Subject: Re: Blastreat, 14 Fitzalan Raod, Arundel West Sussex ; NOTICE of potential CLAIM for DAMAGES

Response to letter from Mr Adrian Burrows

You asked us to respond to the comments in the letter regarding loss of light for planning purposes. Our response makes reference to the document "Daylight and sunlight assessment for proposed development at Fitzalan Road, Arundel" ref: P108661-1003 Issue 2, dated 21 February 2018 ("our assessment"). This was produced in line with the methodology given in the BRE Report "Site layout planning for daylight and sunlight: a guide to good practice" ("the BRE Report"). This document is widely used by local planning authorities to help determine planning applications.

Figure 3: Layout of windows analysed at 2 Fitzalan Road, illustrative only, not to scale.

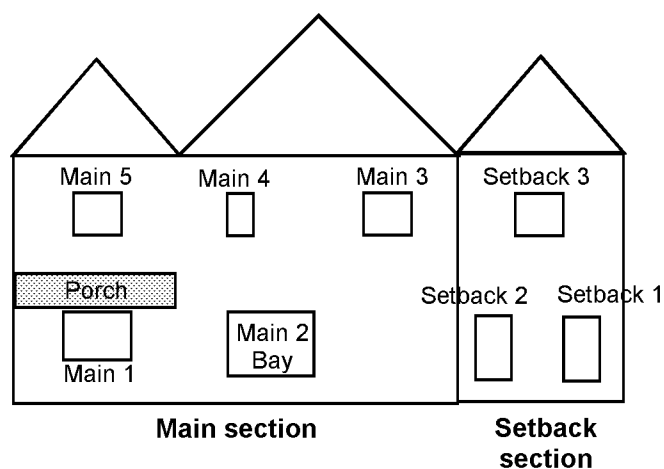
4. The window Mr Burrows refers to is above the garage at 2 Fitzalan Road. It does not directly face the proposed development and therefore would be less impacted than those on the main façade so was not included. Following the concern shown by Mr Burrows for the daylight to this window, we have calculated the vertical sky component in line with the methodology in the BRE Report. The value would be 30.6% with the proposed development in place, above the 27% guideline in the BRE Report; the guidelines would therefore be met and loss of daylight would be small and not significant. Loss of sunlight is not an issue since the window lights a bedroom.

5. The bay window was taken into account in the calculations and is labelled as such in the assessment.
6. It is unclear which cross-sectional drawing Mr Burrows refers to. Cross-sections were not used in the daylight and sunlight analysis. The assessment was based on the positions of the buildings using Ordnance Survey data and the proposed site plan. The distance perpendicular from the bay window to the main proposed development line used in our calculations is in line with what Mr Burrows suggests it should be.
